We have the following comments regarding this application to discharge drainage conditions.

Condition 6 – Surface Water Drainage Design

Application No: BN/57/20/DOC
Registered: 3rd June 2020
Site Address: Land Rear of Lillies Yapton Road Barnham PO22 0AY
Description of Works: Approval of details reserved by condition imposed under ref BN/32/15/OUT relating to Condition Nos 6 - surface water drainage, 7 - discharge flows, 8 - SudS, 9 - future access & maintenance of any watercourse and 10 - surface water drainage

DRAWING NO.	17748-BARN-5-912	REV	A
-------------	------------------	-----	---

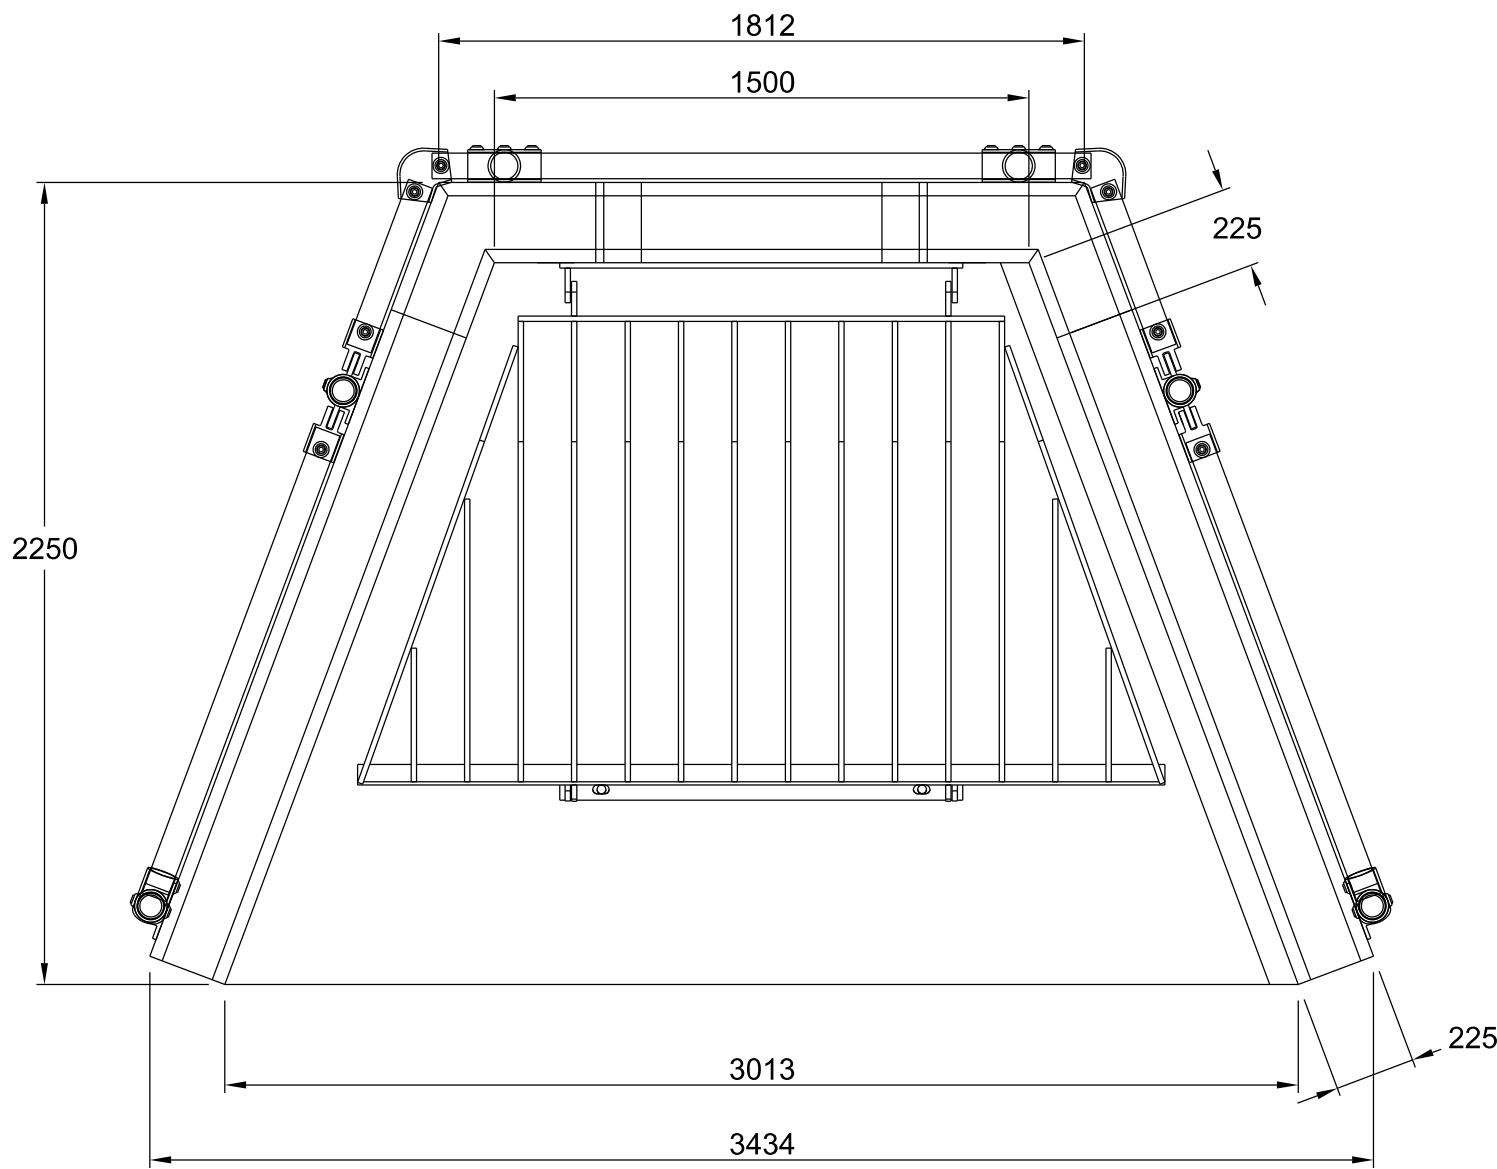
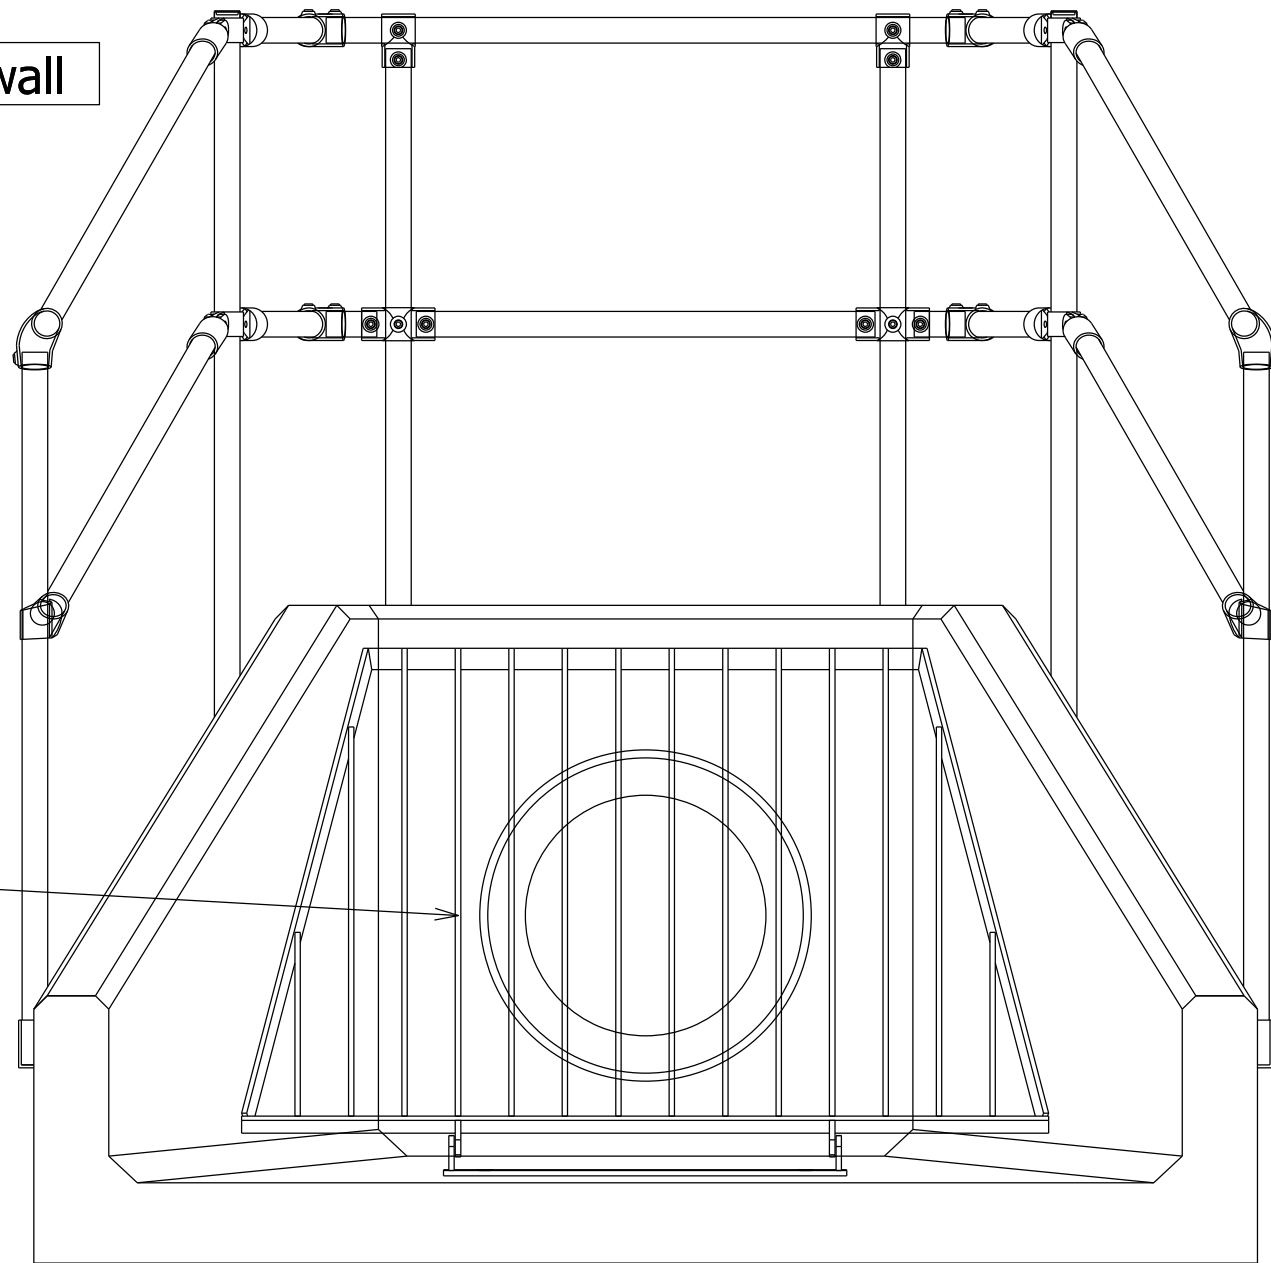
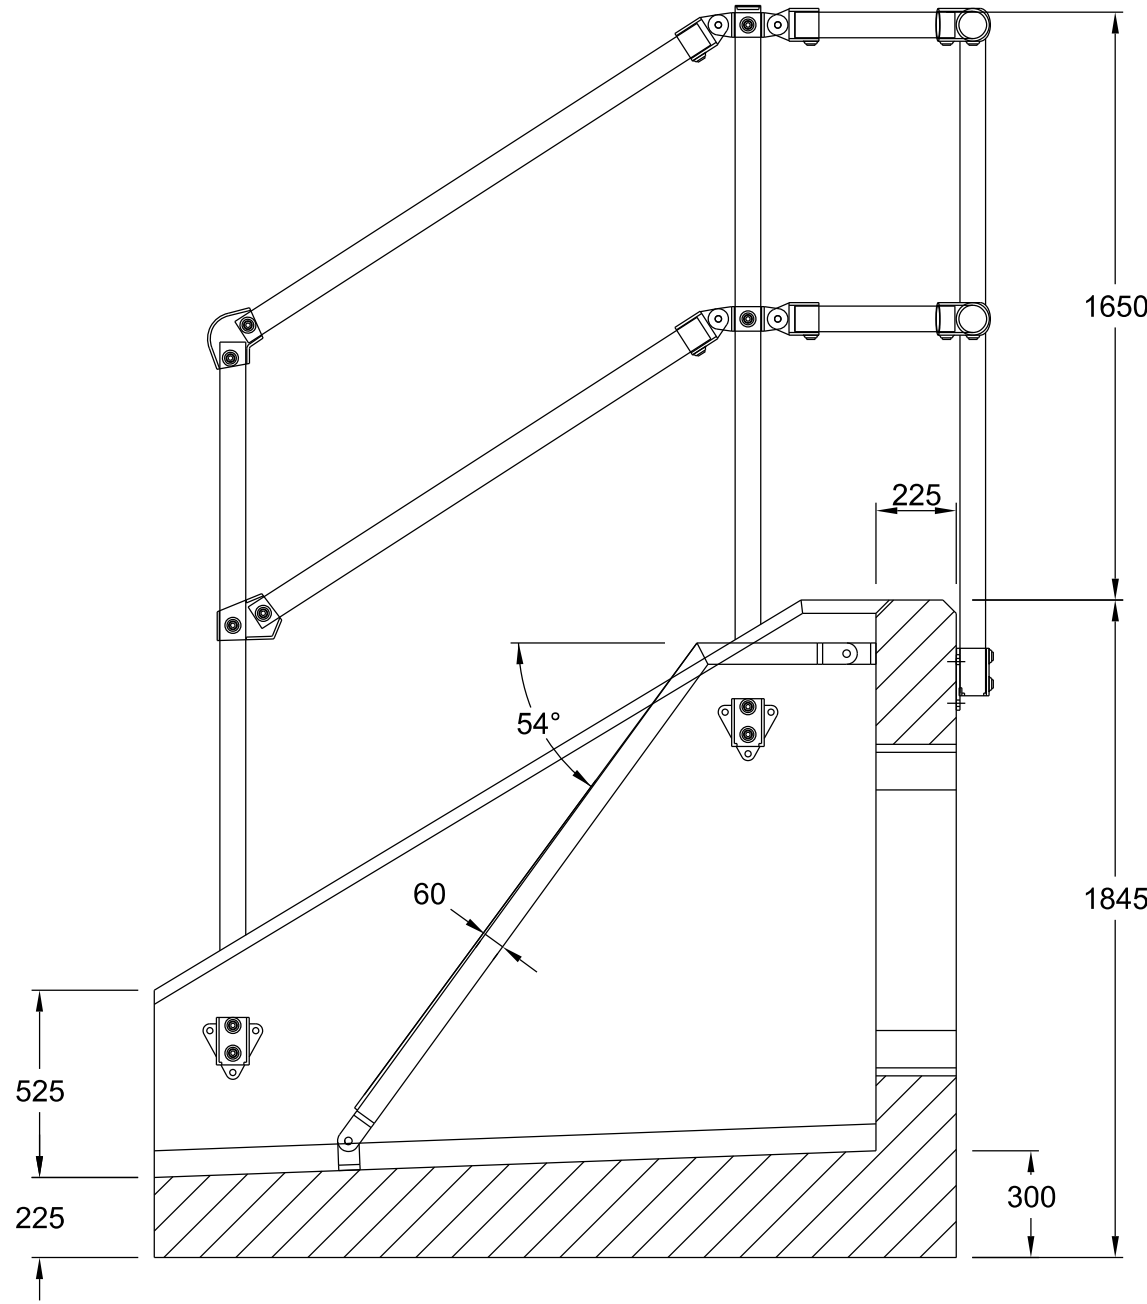
19. Cranked grille must be provided.
20. Please provide further detail of granular material proposed for filter drain. Please indicate ditch invert level at proposed point of connection to watercourse.
21. Please provide construction detail drawings of orifice control chambers. Including detail of blockage protection.
22. Permeable paving construction detail drawing required.
